INFRASTRUCTURE PLANNING

The M4 Motorway (Junctions 3 to 12) (Smart Motorway) (Amendment) Order 2022

An application has been made under paragraph 2 to Schedule 6 of the Planning Act 2008(a) to the Secretary of State in accordance with the Infrastructure Planning (Changes to, and Revocation of, Development Consent Orders) Regulations 2011(b) for a non-material change to the M4 Motorway (Junctions 3 to 12) (Smart Motorway) Development Consent Order 2016(c).

PLAN
SCALE 1:150

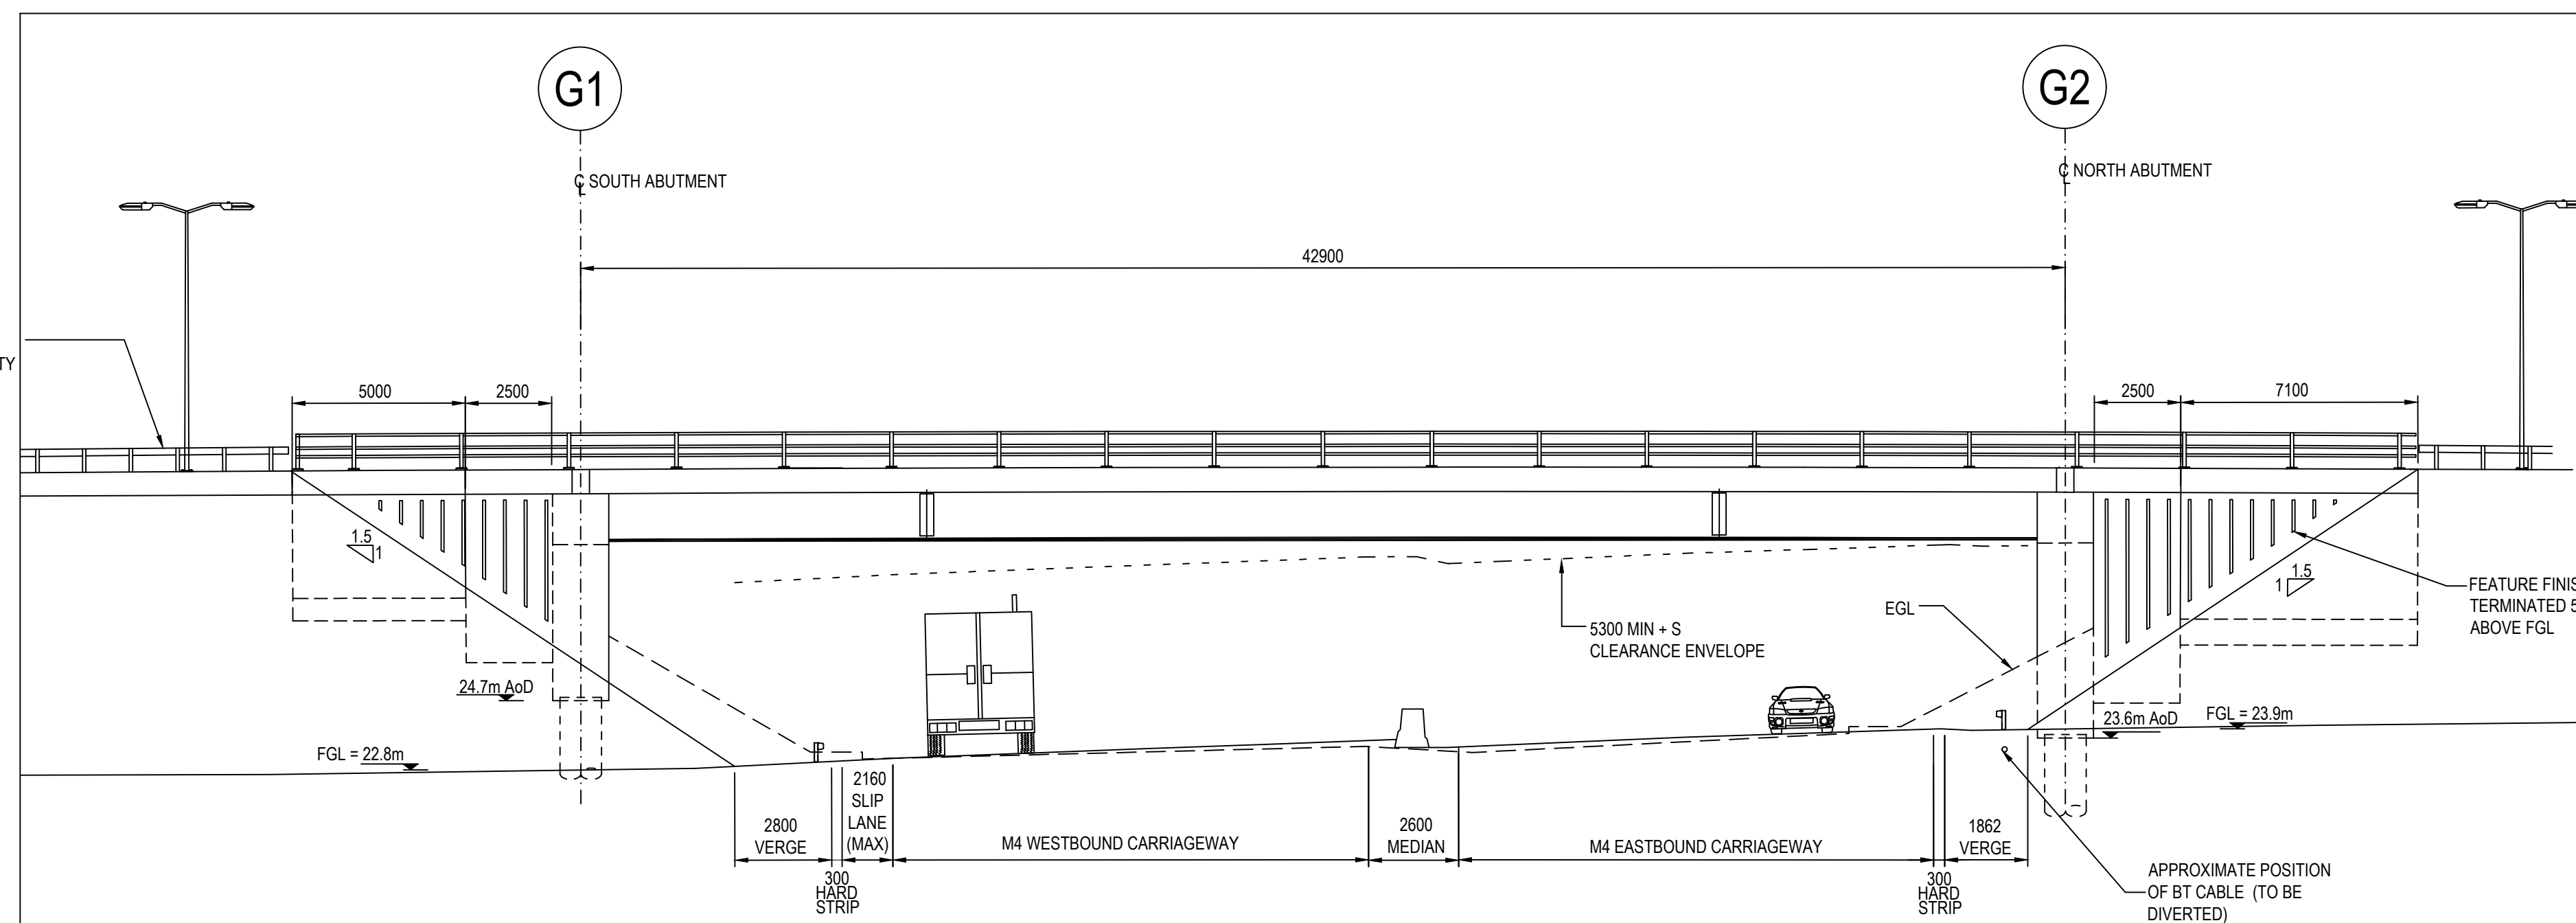
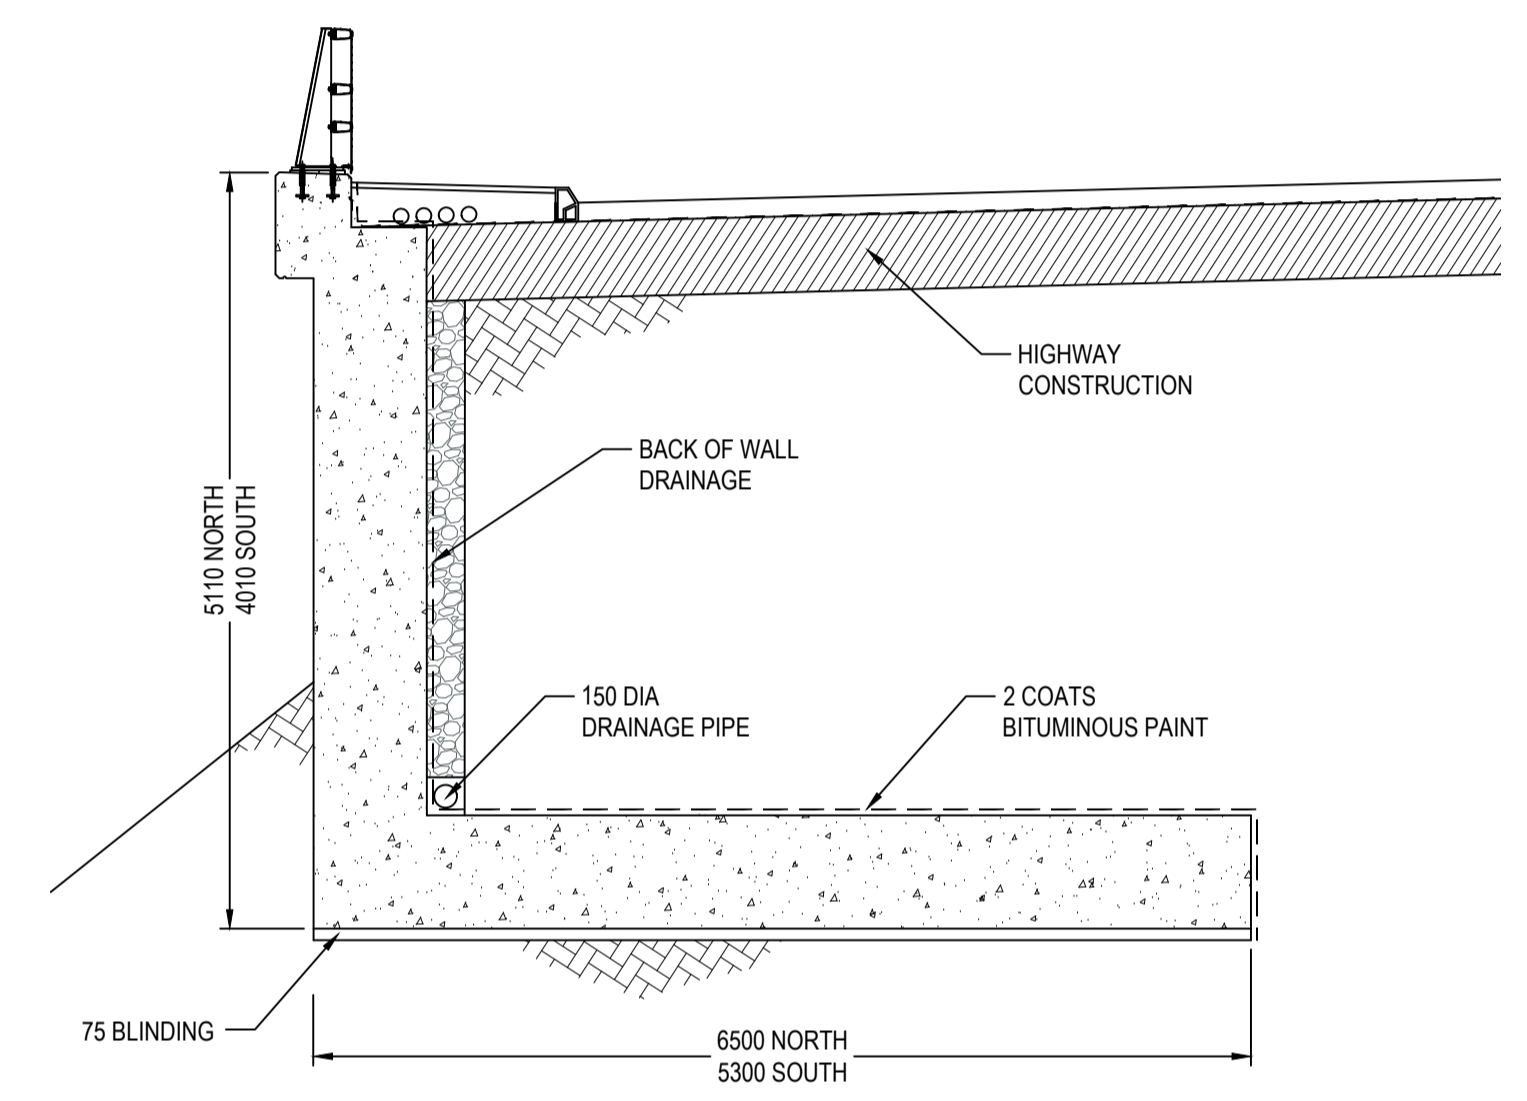
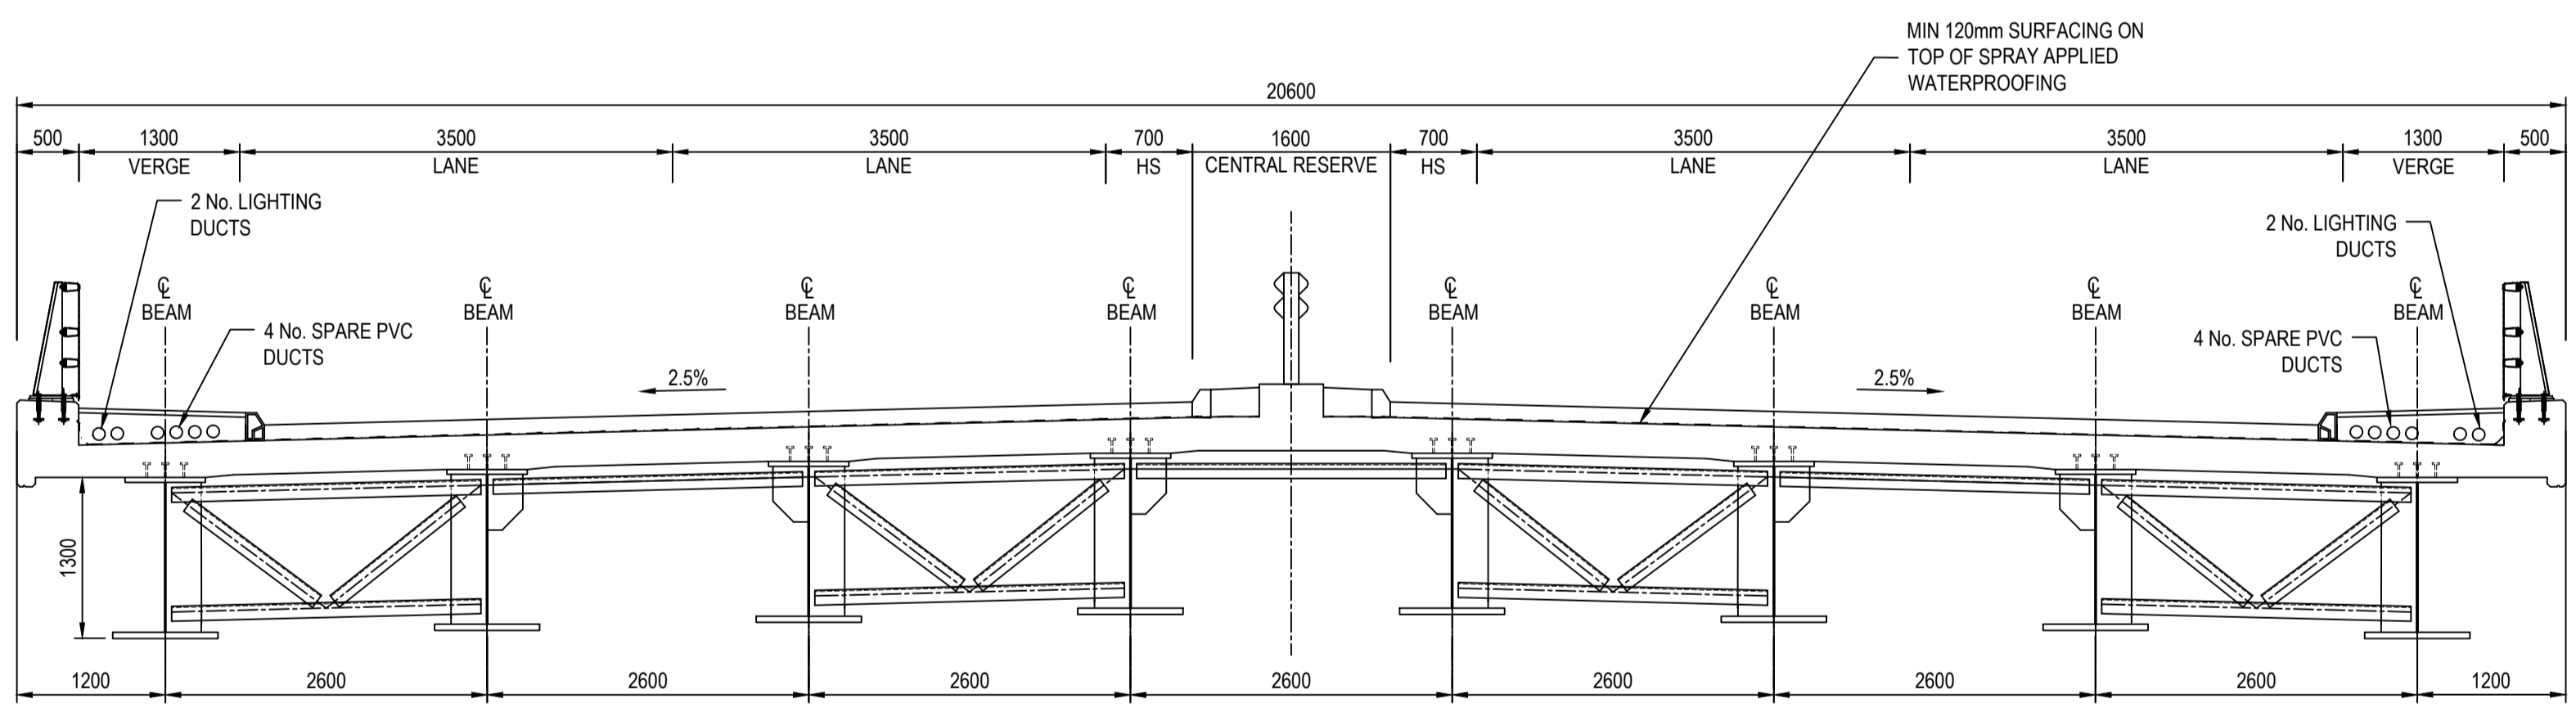
(7) In Work No. 12e—

(a) add the words “single online single span” before the word “bridge”;

(b) add the words “northbound and” before “southbound”;

(c) delete “to the east of the existing Huntercombe Spur overbridge”; and

(d) delete “construction of a new bridge for the northbound carriageway of the Junction 7 Link Road (Huntercombe Spur) over the M4”.
